**Re: PA22-044 – Olympic Vista PRD – Second Final Plat Review**  
4128 Sunnyside Blvd. APN 29050300102200

After review of the above referenced proposal, the Planning Division has the following comment(s):

A.F. NO. _____ SHEET 1 of 3

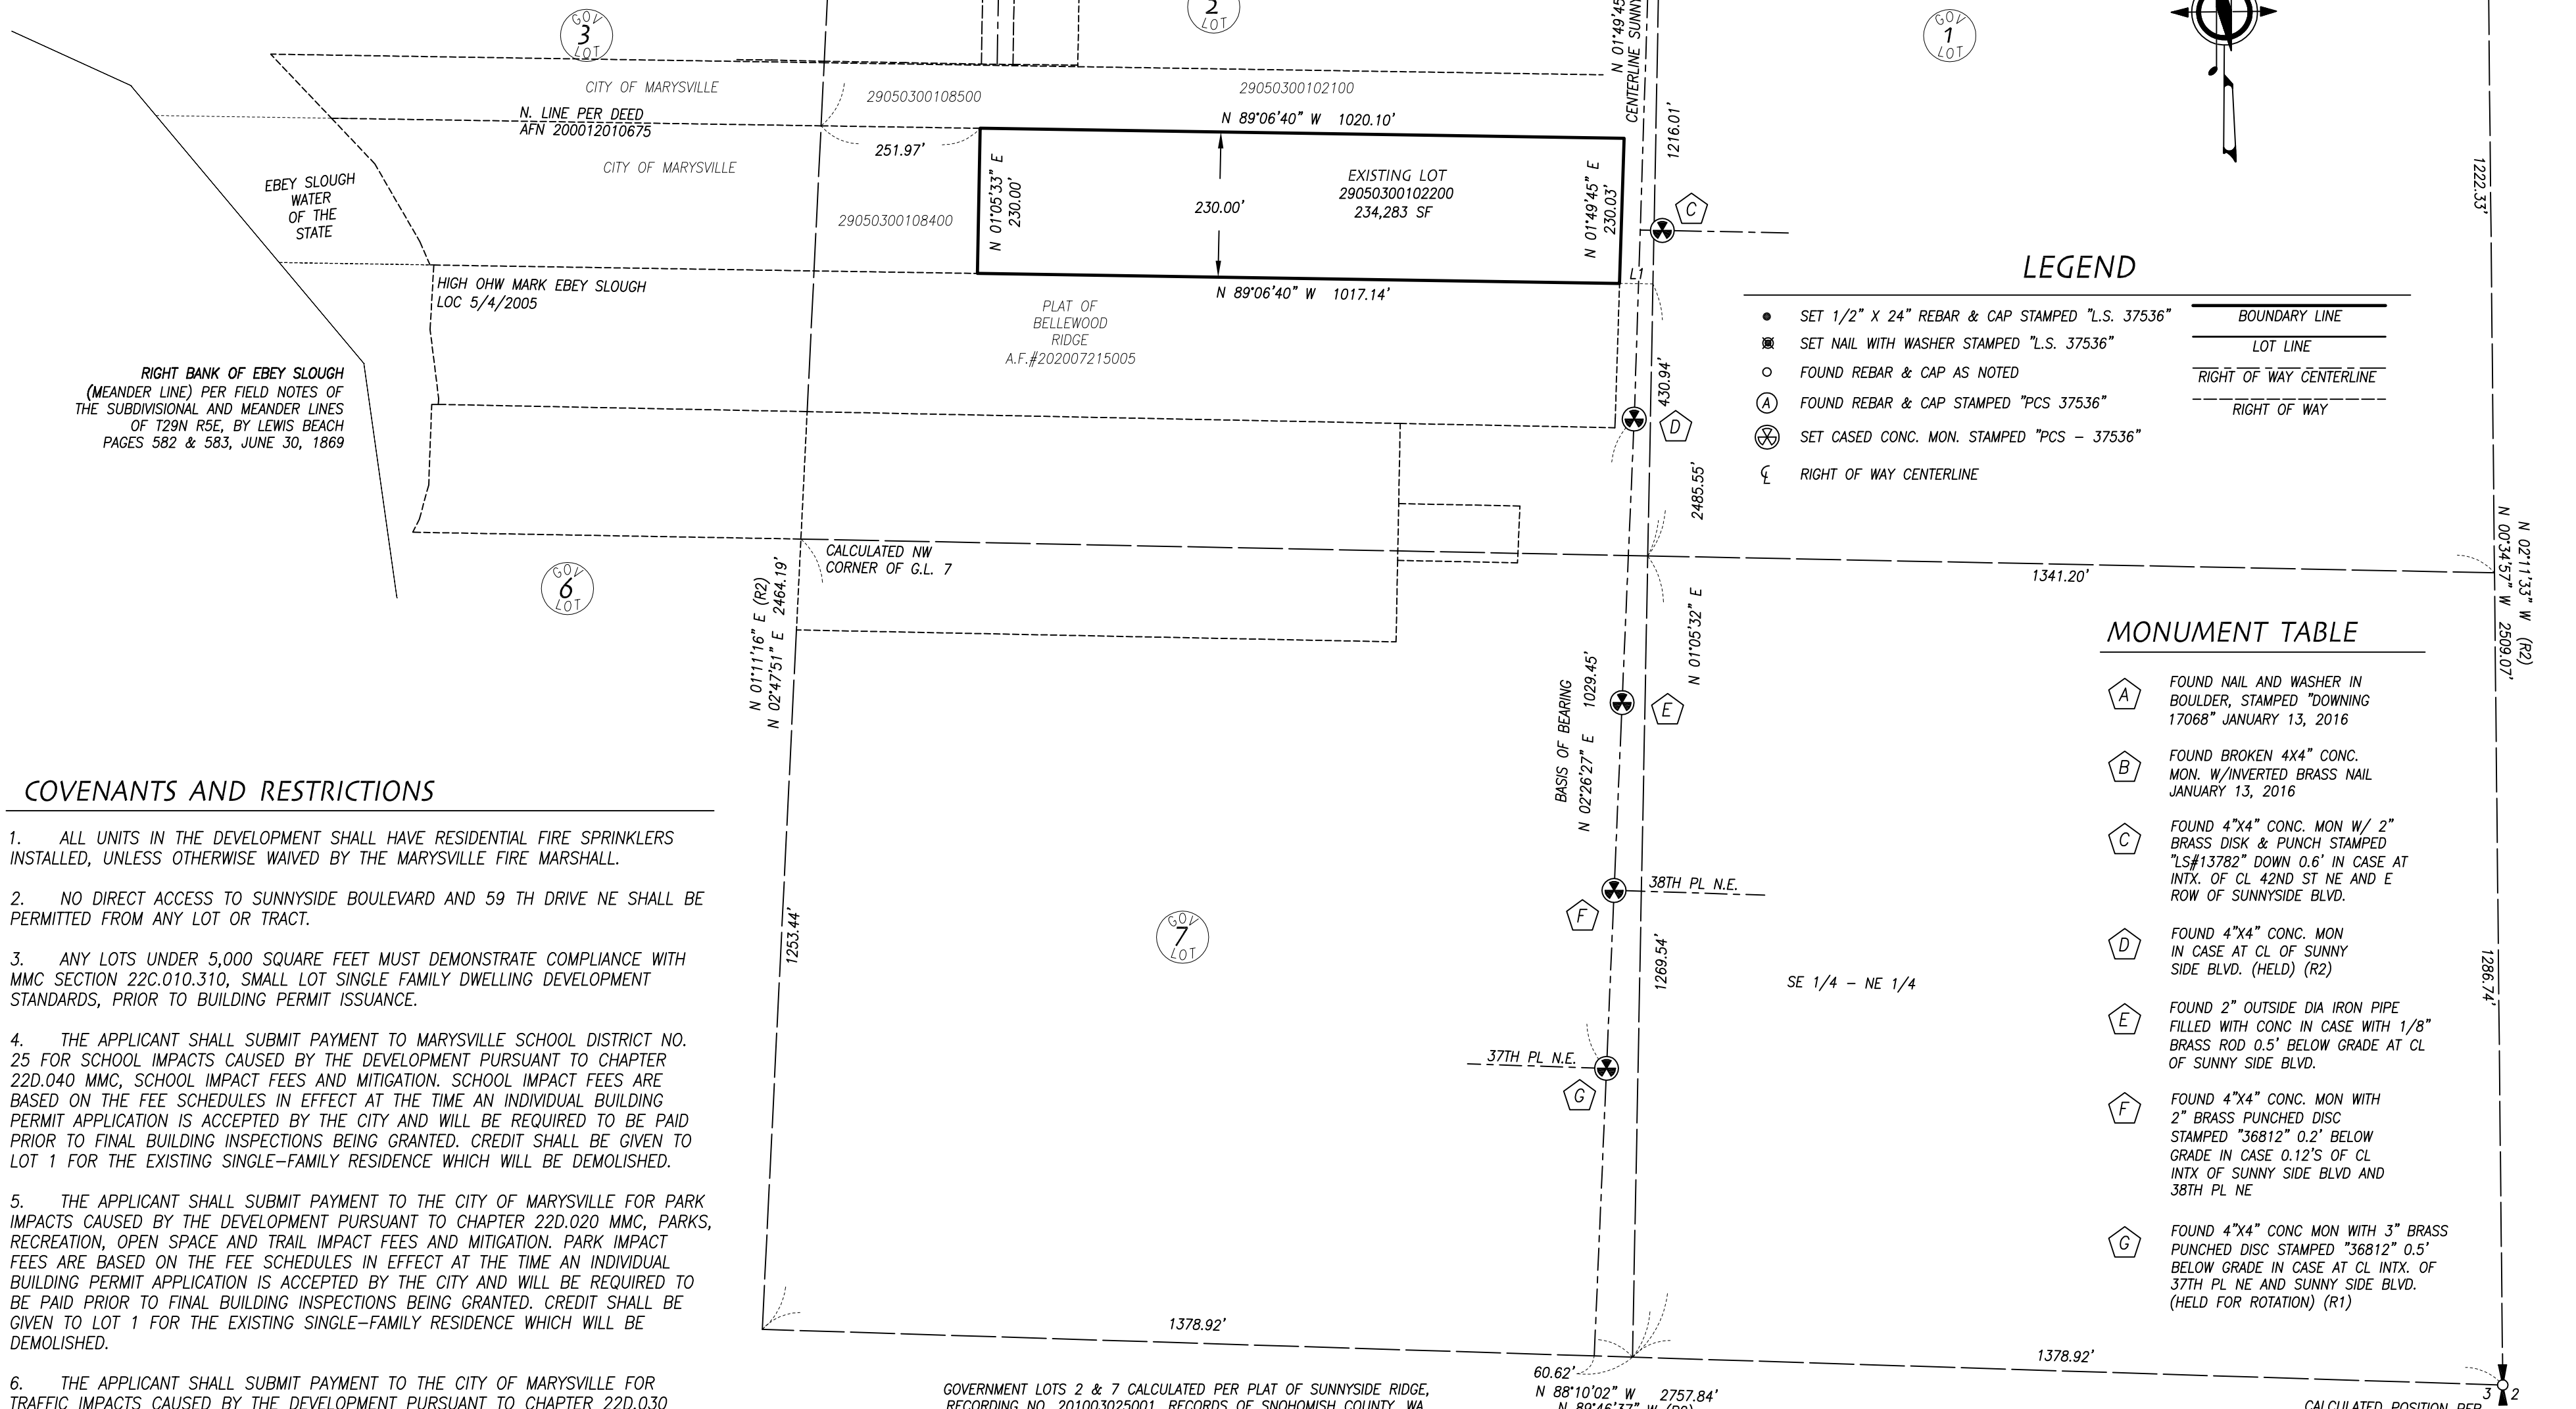
1. Please revise the restriction for traffic impact fees as shown below:

6. THE APPLICANT SHALL SUBMIT PAYMENT TO THE CITY OF MARYSVILLE FOR TRAFFIC IMPACTS CAUSED BY THE DEVELOPMENT PURSUANT TO CHAPTER 22D.030 MMC, IN THE AMOUNT OF \$6,300.00. ~~TRAFFIC IMPACT FEES ARE BASED ON THE FEE SCHEDULES IN EFFECT AT THE TIME AN INDIVIDUAL BUILDING PERMIT APPLICATION IS ACCEPTED BY THE CITY AND WILL BE REQUIRED TO BE PAID PRIOR TO FINAL BUILDING INSPECTIONS BEING GRANTED. CREDIT SHALL BE GIVEN TO LOT 1 FOR THE EXISTING SINGLE-FAMILY RESIDENCE WHICH WILL BE DEMOLISHED.~~

2. Please add a restriction prohibiting the establishment of Accessory Dwelling Units (ADU's) within the PRD. This restriction does in fact need to be included, per my email dated 10.2.2023.
